**City of Portland, Maine - Building or Use Permit Application**  
 389 Congress Street, 04101 Tel: (207) 874-8703, Fax: (207) 874-8716

<b>Permit No:</b> 08-0294	<b>Issue Date:</b>	<b>CBL:</b> 160 E021001
------------------------------	--------------------	----------------------------

<b>Past Use:</b> Vacant Land	<b>Proposed Use:</b> Single Family Home - New single family home w/ attached 2 car garage	<b>Permit Fee:</b> \$2,255.00	<b>Cost of Work:</b> \$216,000.00	<b>CEO District:</b> 4
<b>Proposed Project Description:</b> New single family home w/ attached 2 car garage		<b>FIRE DEPT:</b> <input type="checkbox"/> Approved <input type="checkbox"/> Denied	<b>INSPECTION:</b> Use Group: Type	
		Signature:	Signature:	
<b>PEDESTRIAN ACTIVITIES DISTRICT (P.A.D.)</b>				
Action <input type="checkbox"/> Approved <input type="checkbox"/> Approved w/Condition <input type="checkbox"/> Denied				
		Signature:	Date:

**Dept:** Building      **Status:** Approved with Conditions      **Reviewer:** Tammy Munson      **Approval Date:** 05/23/2008

LOT #2
12,357.9 SQ. FT.

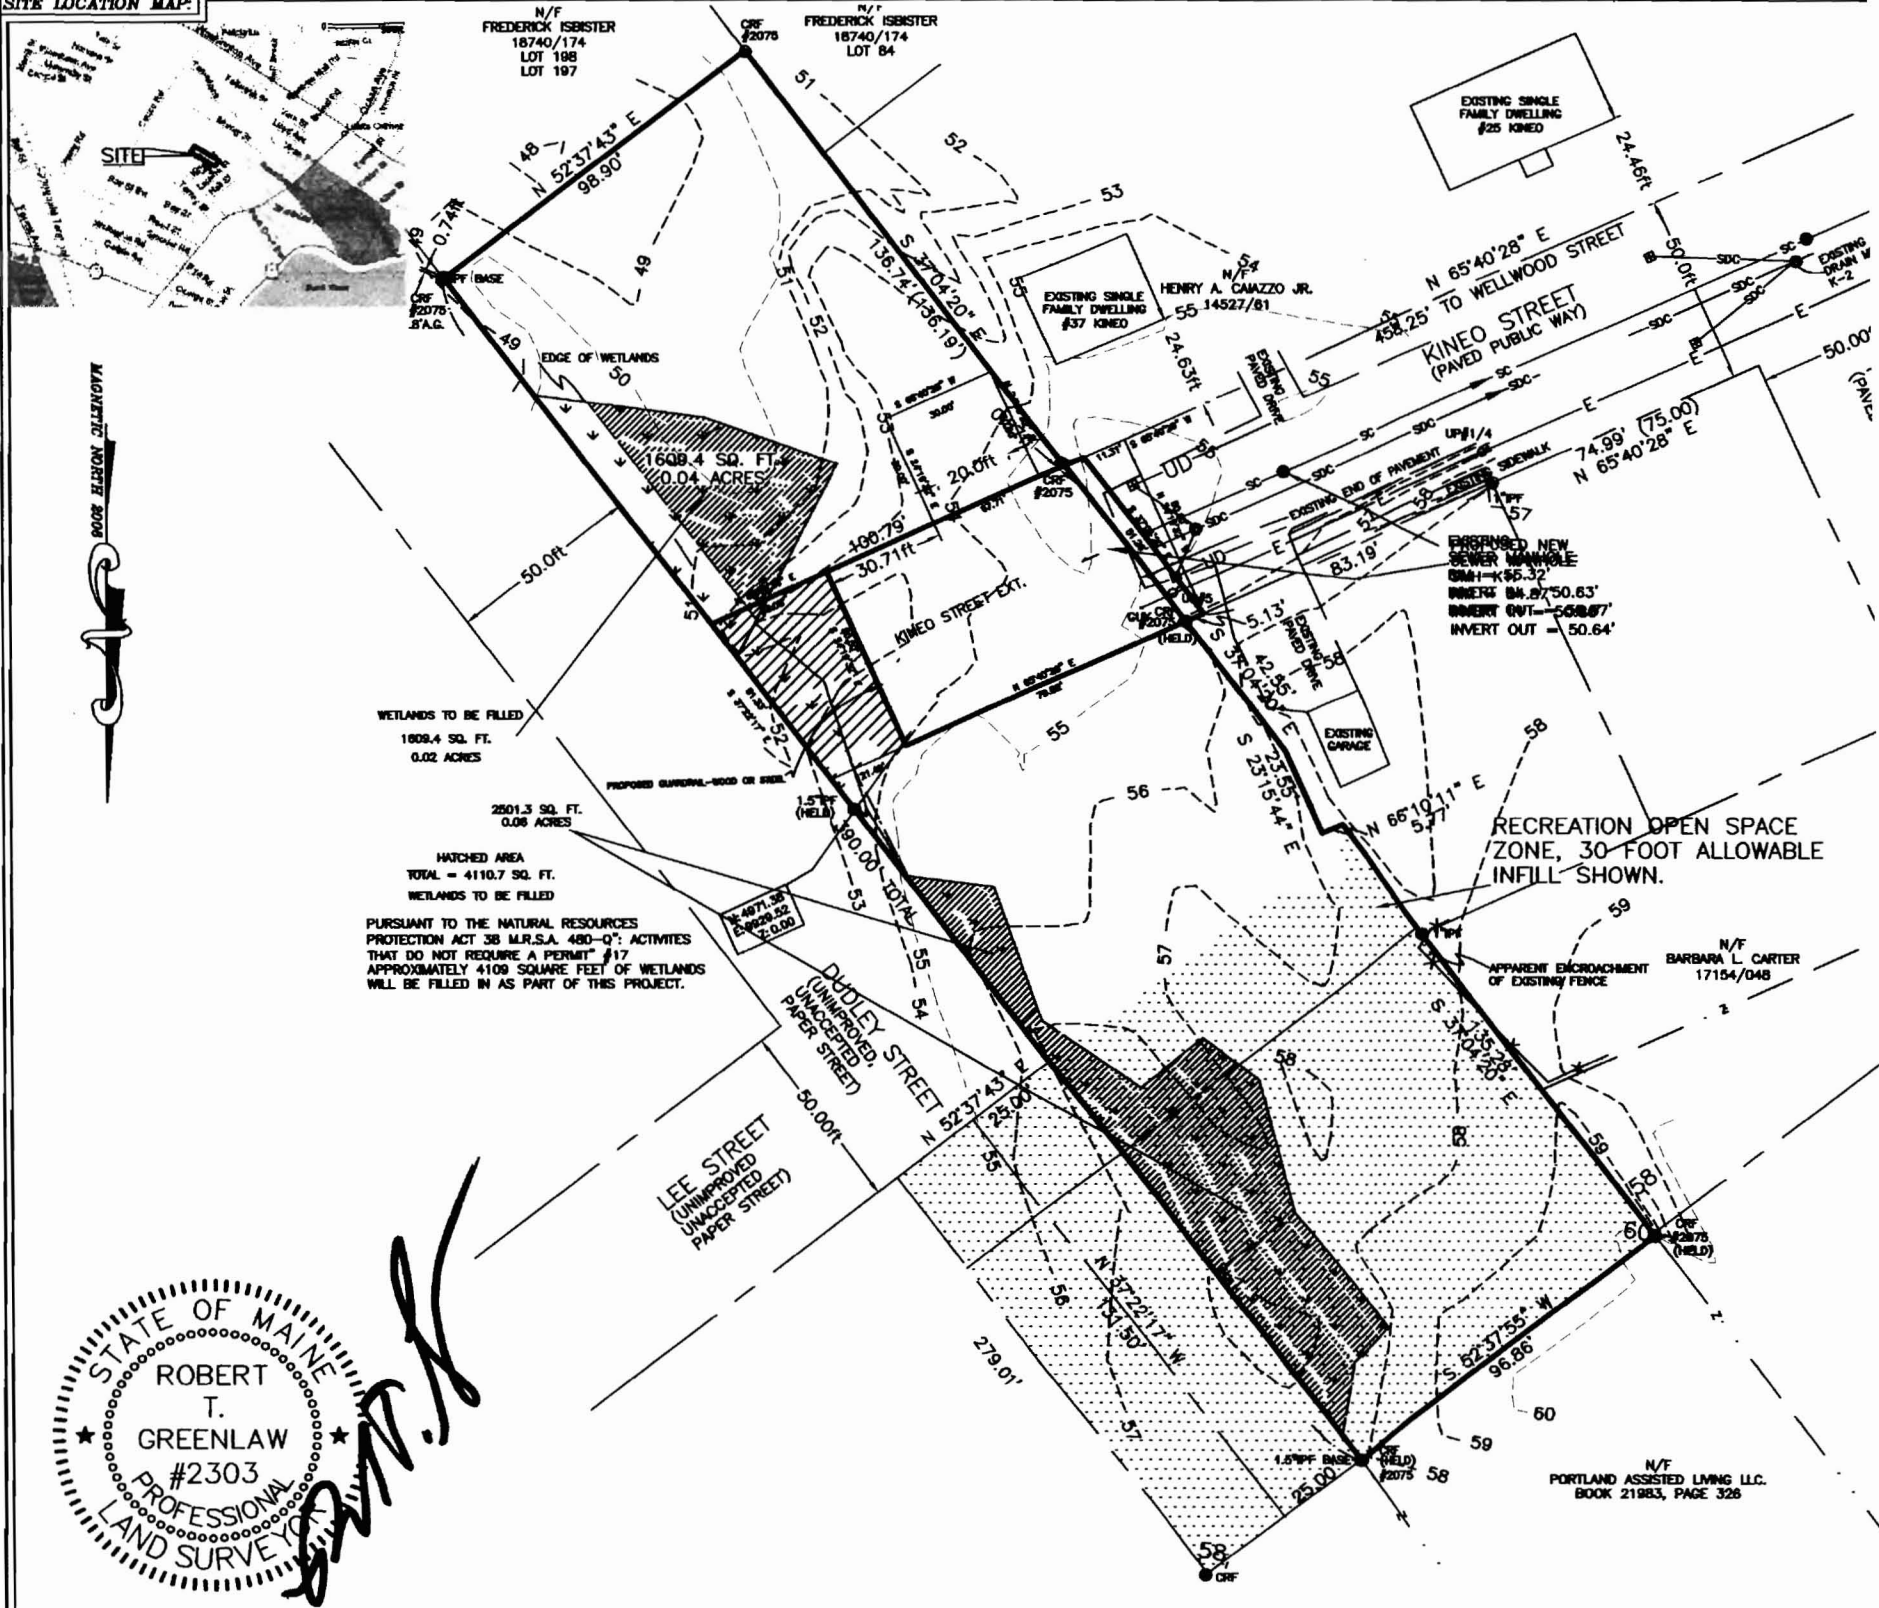
4/3/2008-amachado: Left message for Eric Theriault. Siteplan not to scale; it has been slightly reduced. Site plan does not show deck or steps coming off. Doghouse on site plan also is not clear and needs to match the location shown on the building plans. If there will be any front steps, they need to be shown. Before we issue the permit we need to have acopy of the deed that describes the specific lot.

4/10/2008-amachado: Received scalable siteplan and description of lot 2 from Bob Greenlaw on 4/8/08. Called the buyer Eric Theriault and told him that the proposed house does not meet the 20' side setback on a side street. He asked me to call Bob Greenlaw. I spoke to Bob and told him about the side setback. I also asked him to review the legal description because the last bearing and distance does not make sense.

4/11/2008-amachado: Received revised siteplan and legal description. Proposed house now meets the side setback on a side street.
